**From:** Anderson, Ryan (ECY) <rand461@ECY.WA.GOV>  
**Sent:** Monday, December 18, 2023 3:36 PM  
**To:** Bradley Gasawski  
**Subject:** RE: SV-23-00001 Horish - Notice of Application

The new driveway constitutes development proposed to replace existing access to parcel 516534. Documents supporting the Boundary Line Adjustment of parcel 546534 show that an existing driveway provides access to the potential building site noted in the application. This existing driveway provides access to the site with minimal disturbance to the shoreline and shoreline wetland buffers. The proposed driveway increases disturbance to the shoreline environment and shoreline wetland buffer.

**Shoreline**

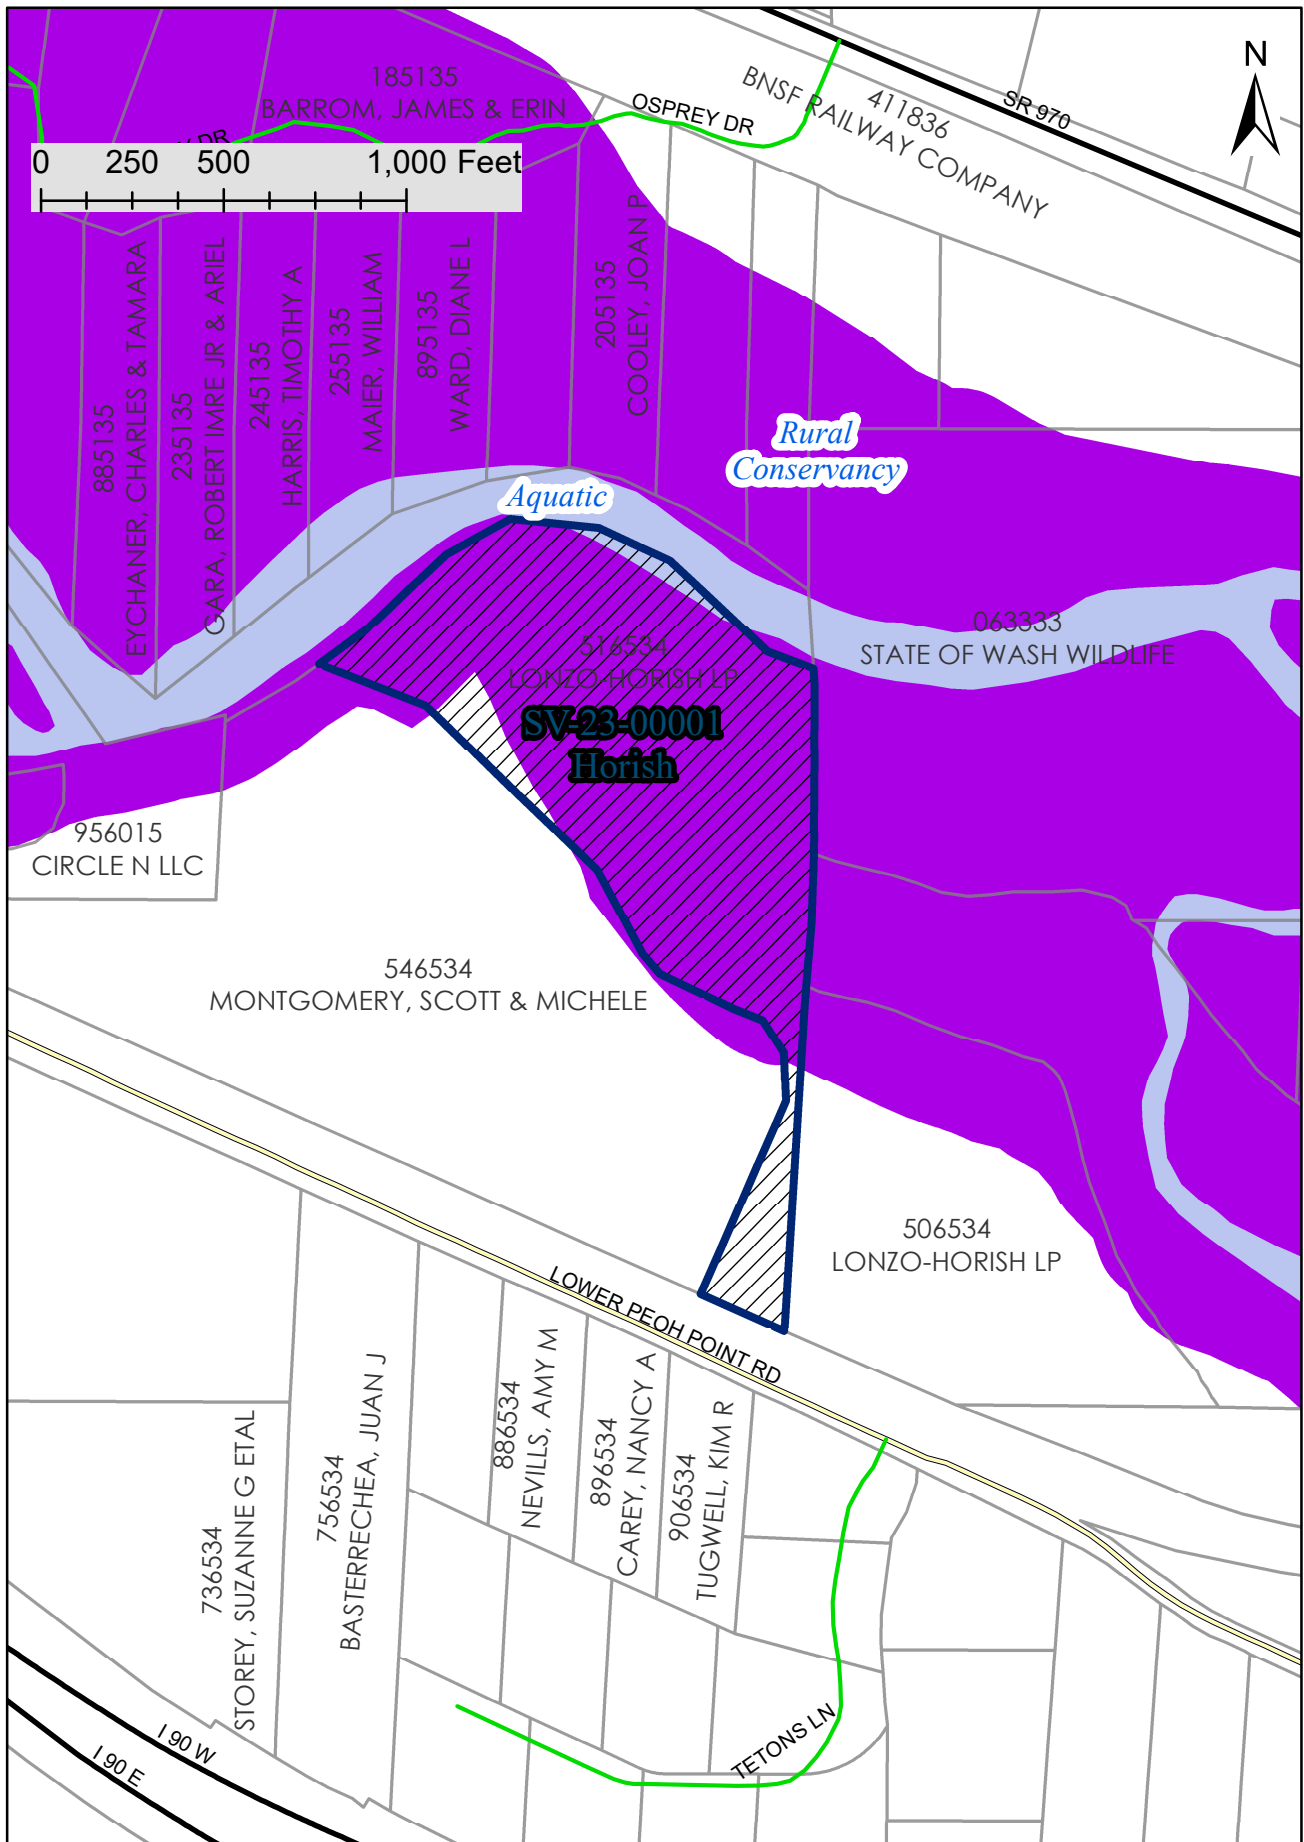
For additional and future consideration, the proposed future building site is very near the floodway, in rural conservancy shoreline jurisdiction, lies within the 100 year floodplain, and within the buffer of riverine wetlands. These considerations were all discussed when Ecology and Kittitas County visited the site on June 2, 2023 and may restrict development on site or require increased evaluation and analysis if development is considered in the future. Please reach out to Ryan Anderson ([509379-1917/rand461@ecy.wa.gov](mailto:509379-1917/rand461@ecy.wa.gov)) if you have any questions about these comments.

WAC 173-27-180 provides a list of material necessary for a complete application. On the June 2, 2023 site visit and notes following that up, several alternatives to driveway alignment were discussed. The application should provide a site plan that shows these alternatives as part of a complete application.
